**Our Case Number:** ABP-317660-23

**Re:** Bus Connects Kimmage to City Centre core bus corridor scheme  
Kimmage, Dublin

**RE: SUBMISSION TO AN BORD PLEANÁLA – TO CITY CENTRE CORE BUS CORRIDOR  
HA 29N: 317660**

**Submission by Harold's Cross Village Community Council on the Kimmage to City Centre Core Bus Corridor Scheme HA 29N: 317660**

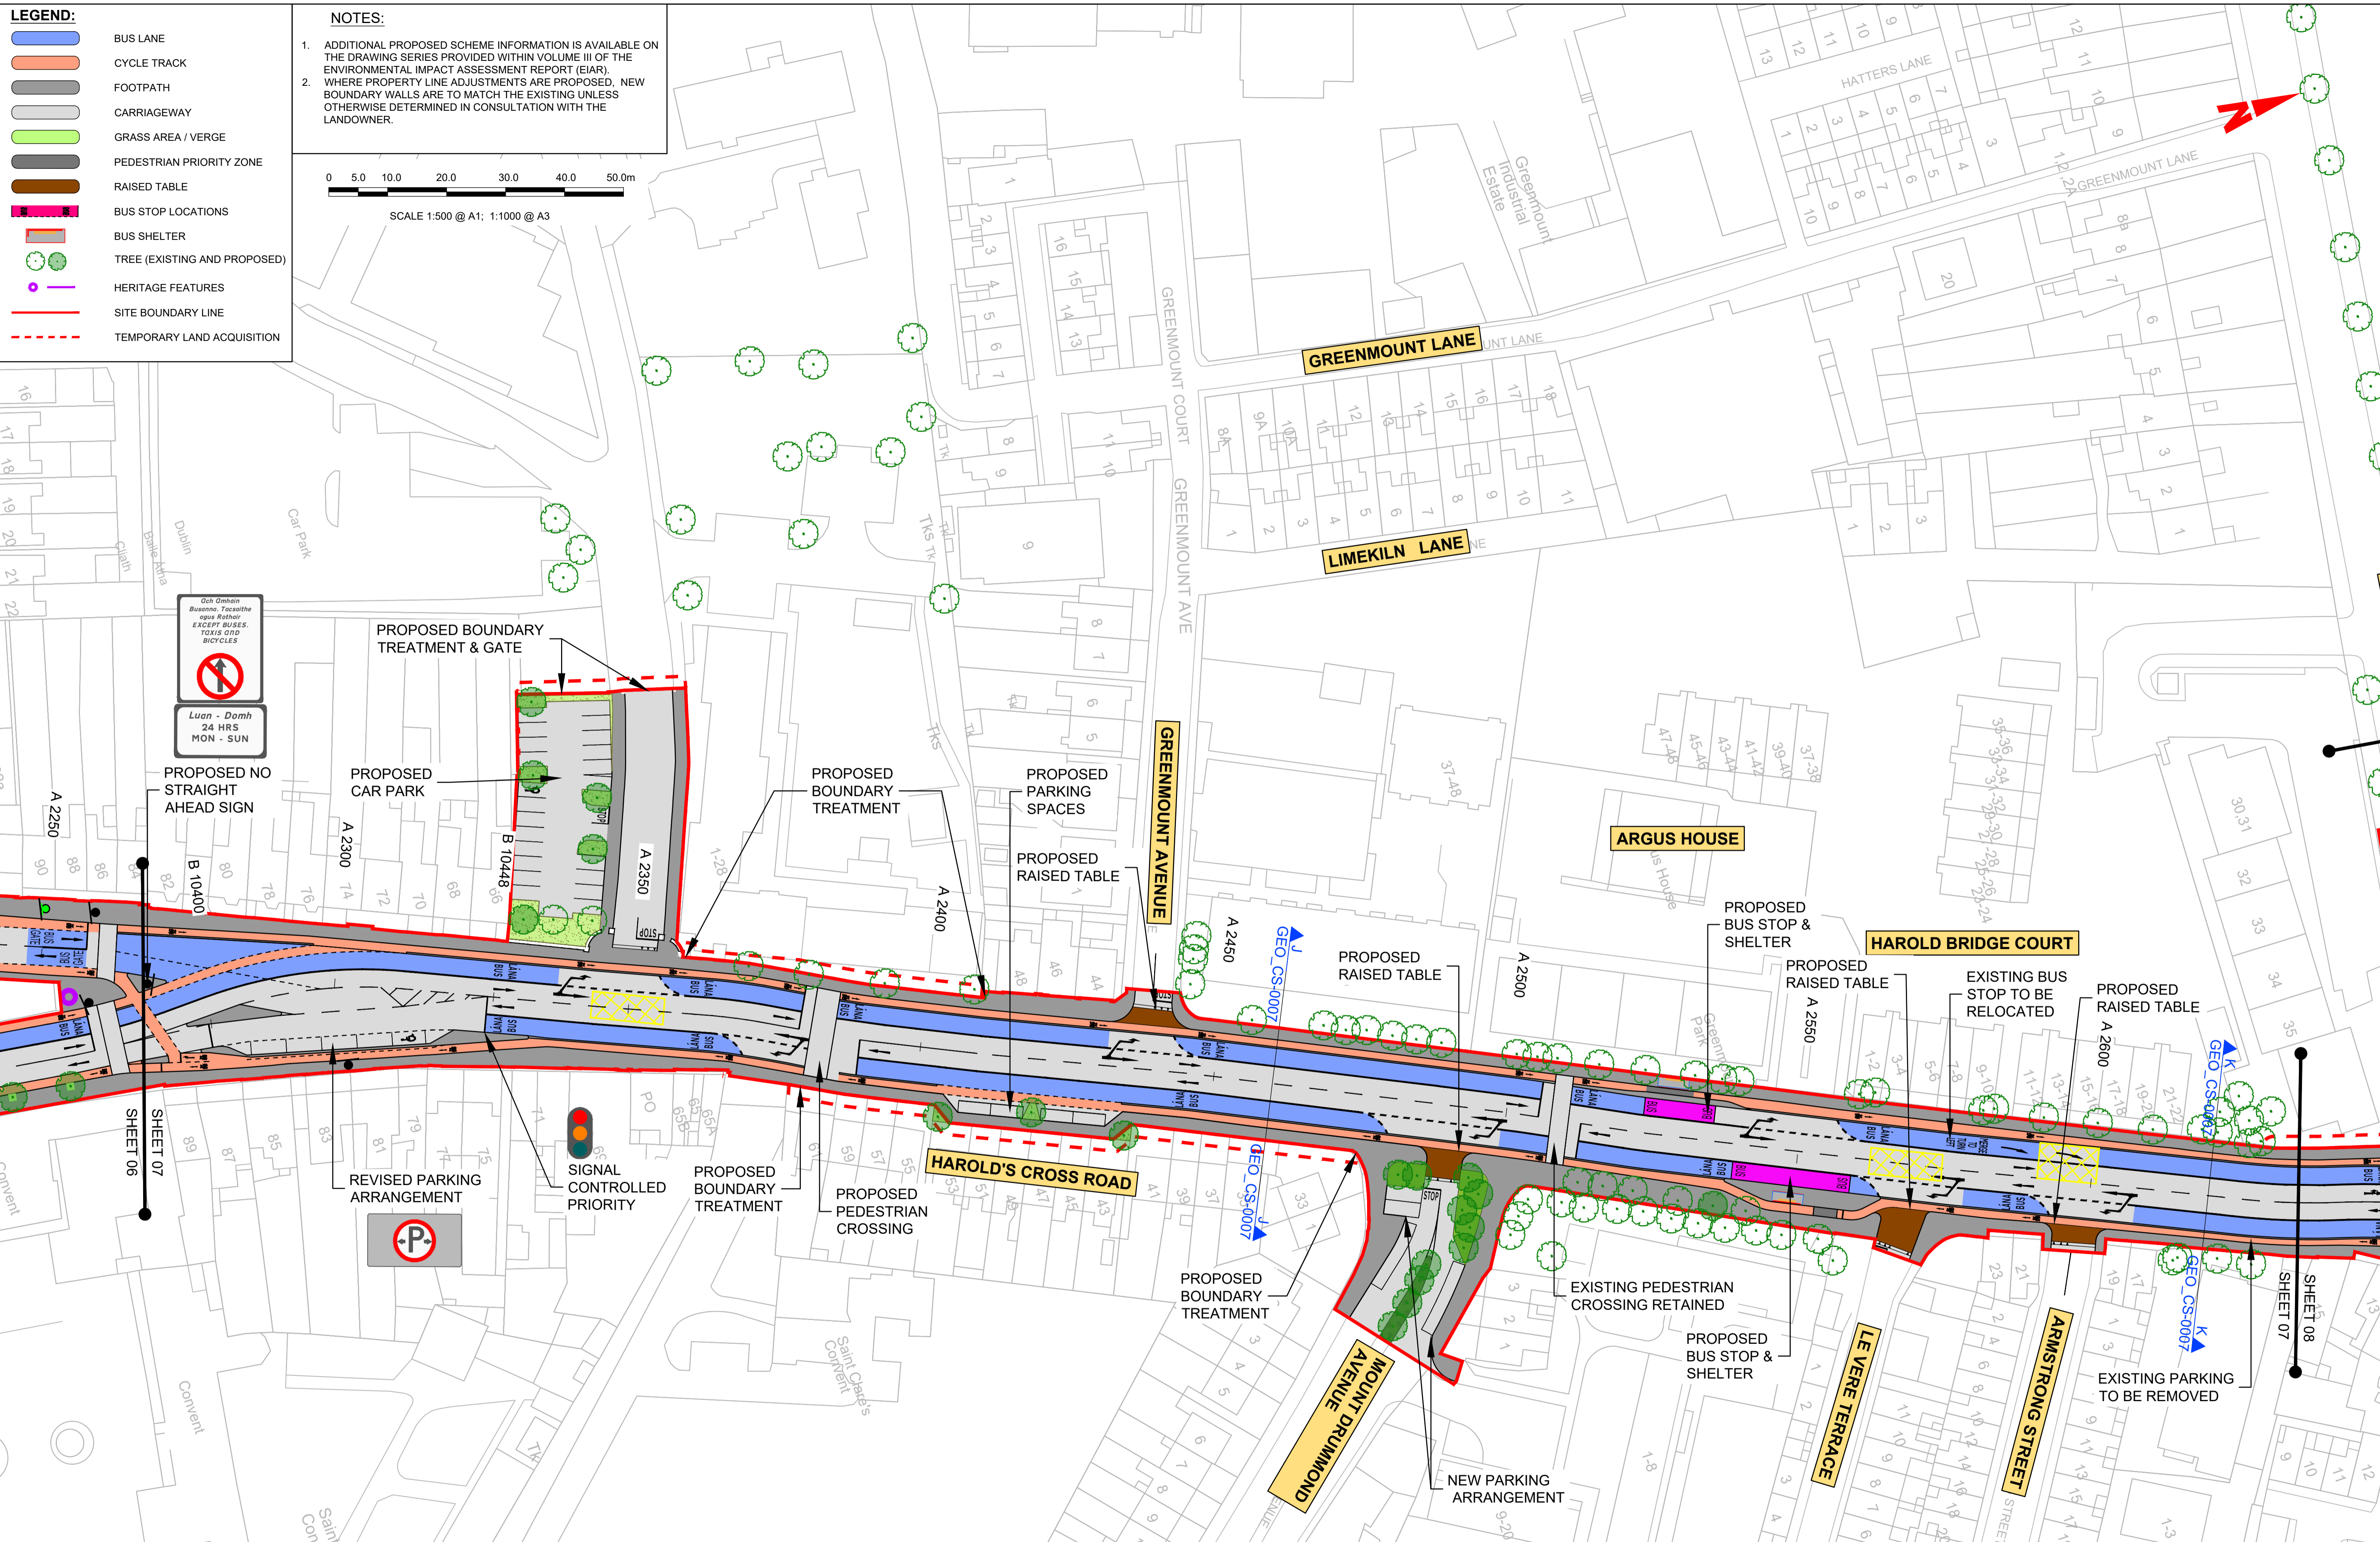
However, the text and the drawings are unclear and do not correspond. The text above does not seem to match the drawing on Sheet no 6 of the General Arrangement drawings no BCIDD-ROT-GEO\_GA-0011\_XX\_00-DR-CR-0006 where a bus gate is shown in markings on both sides of the carriageway, north and southbound.

Drawing File Name: BCIDD-ROT-GEO_GA-0011_XX_00-DR-CR-0007
Sheet Number: 07 of 14
Status: A
Rev: M01

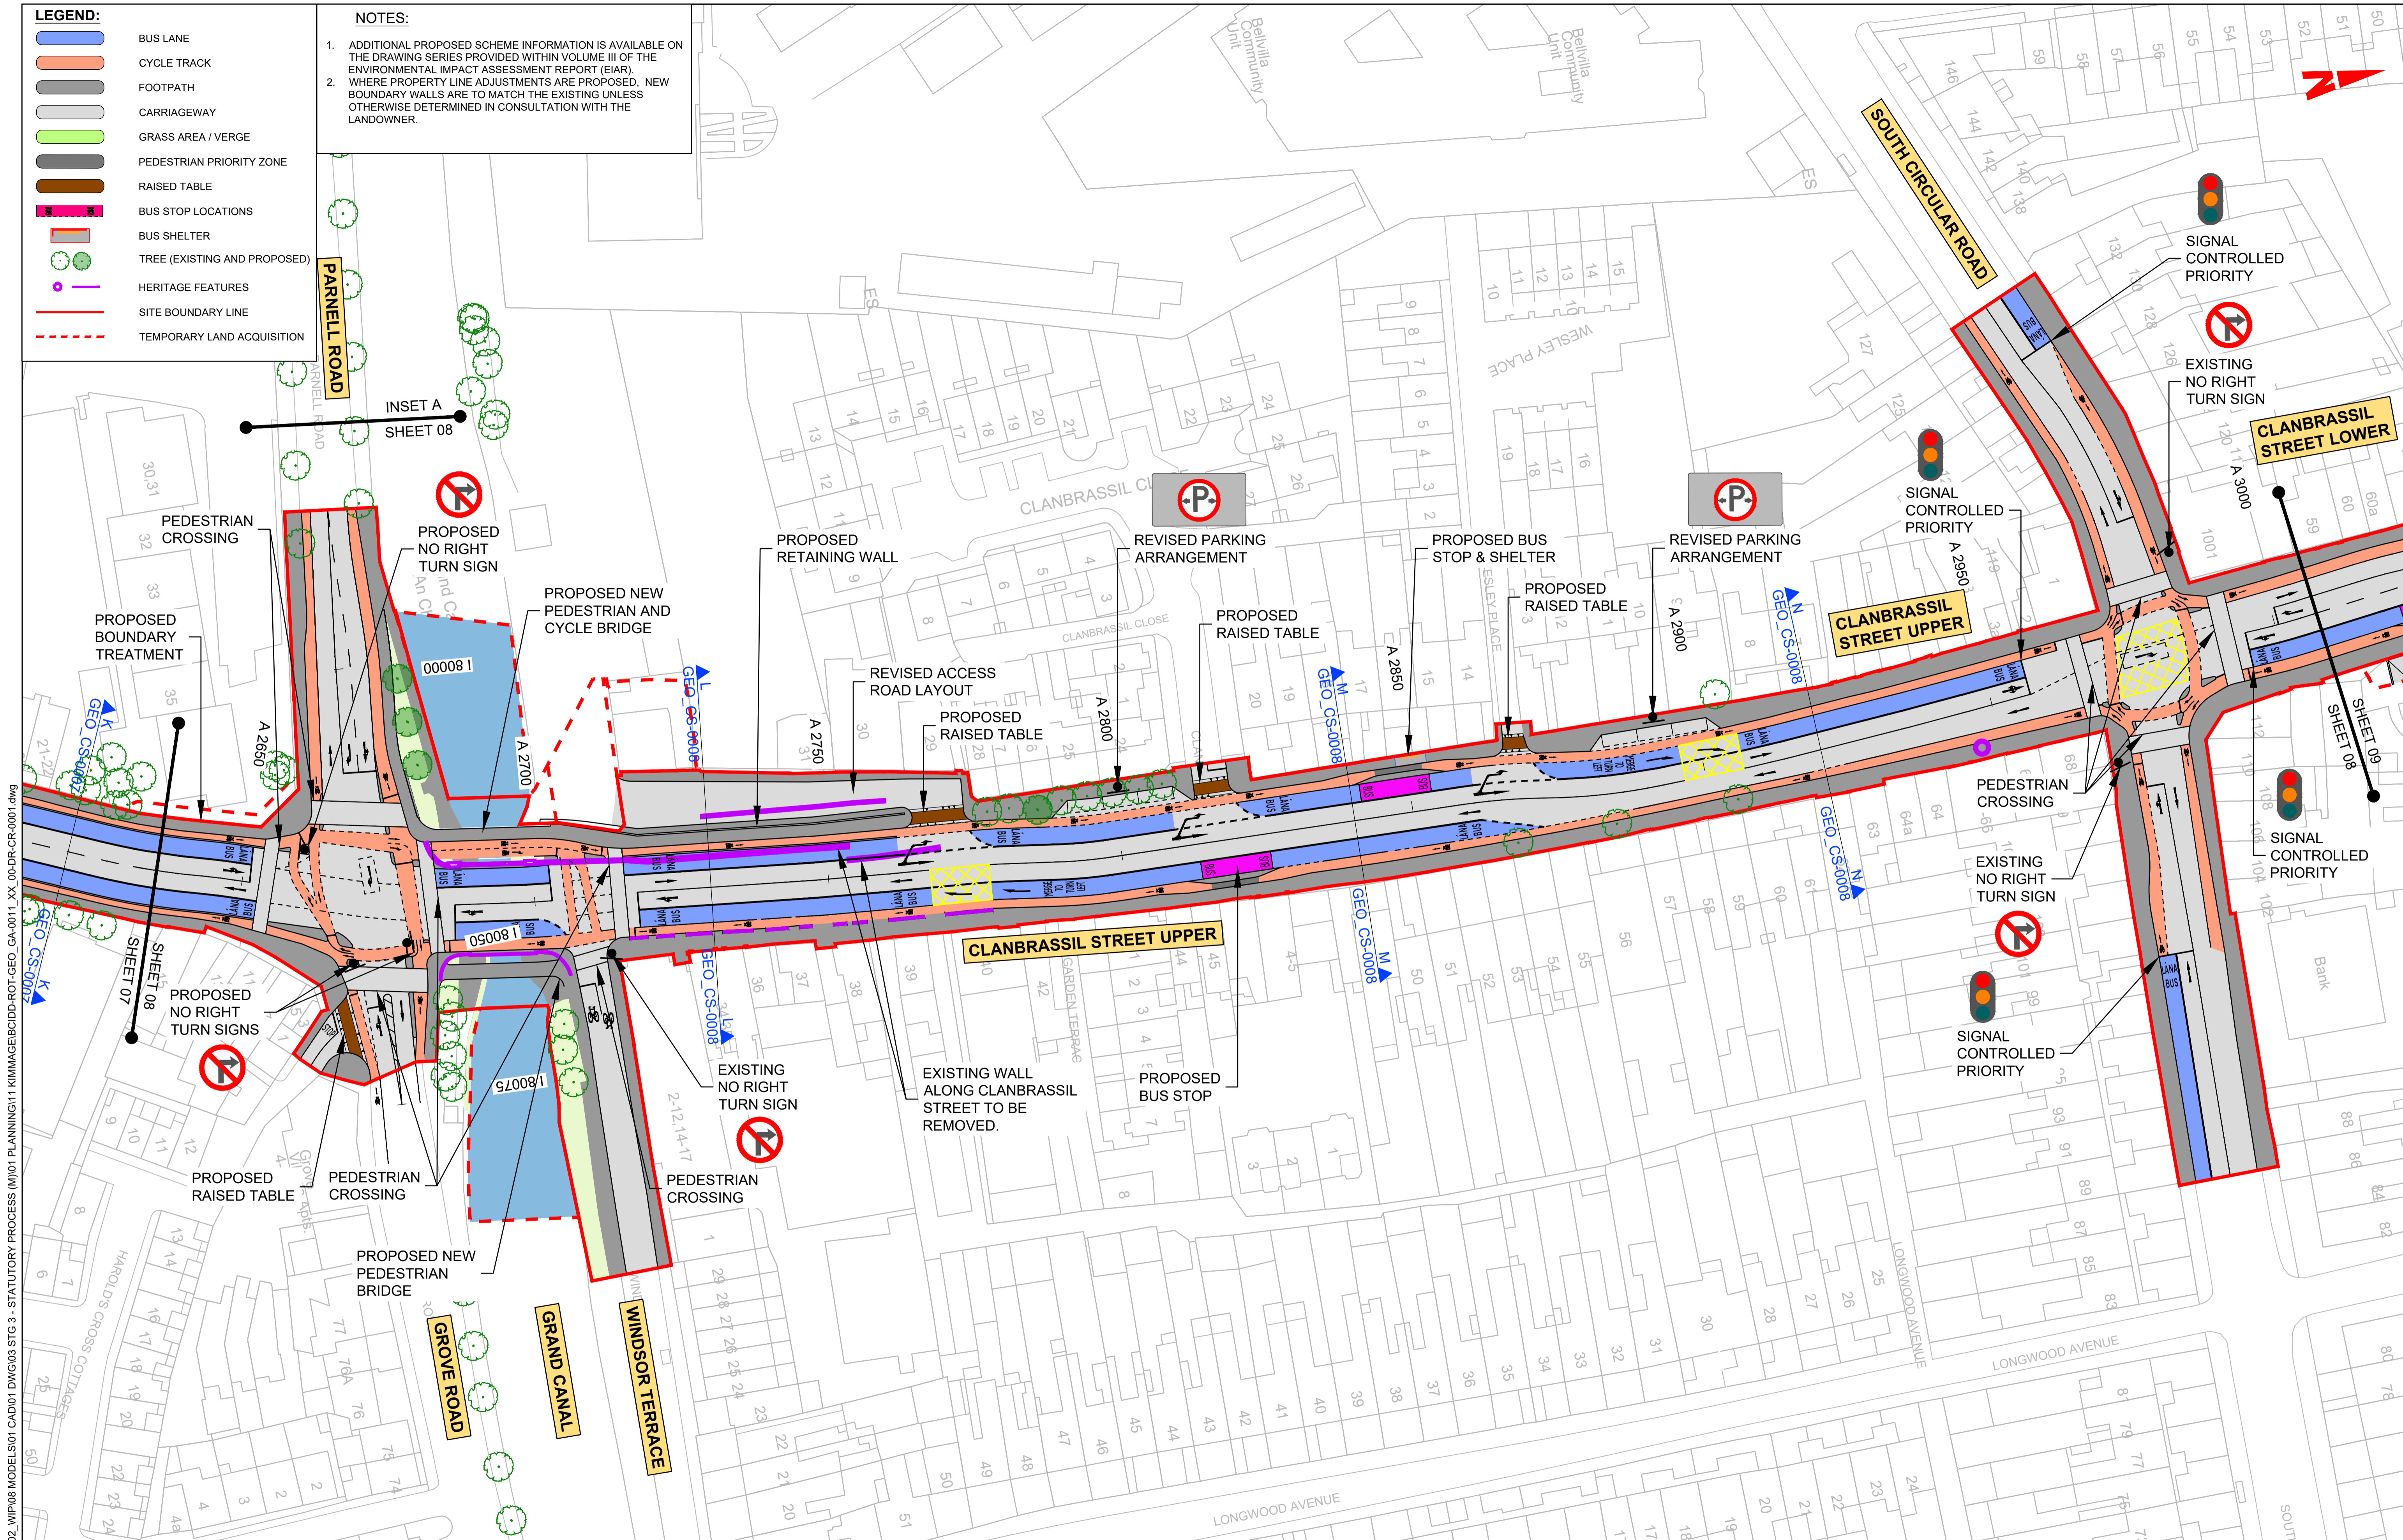
Furthermore, the signage indicated on drawing on Sheet no 7 states that the bus gate towards the south along the western side of Harold's Cross Park will operate 24 hours. This ties in with the text on pg. 27 of Vol 2 Chp. 4 EIAR. Which states *Southbound traffic on R137*

Signage alerting drivers to this effect is needed at the southern end of Harold's park to alert traffic heading north (towards the city) in the morning peak that they will not be able to utilise the linking road across the top of the park as they are prohibited during this time from either turning left at Mc Gowans (Bus Gate 2A), or turning right towards the Mount Jerome and on to the Siopa Linn bus gate(Bus Gate 2B). Although there is an indication on Map 6 (drawing BCIDD-ROT-GEO\_GA-0011\_XX\_00-DR-CR-0006) of a sign giving advance warning of the bus gates– detail will be required.
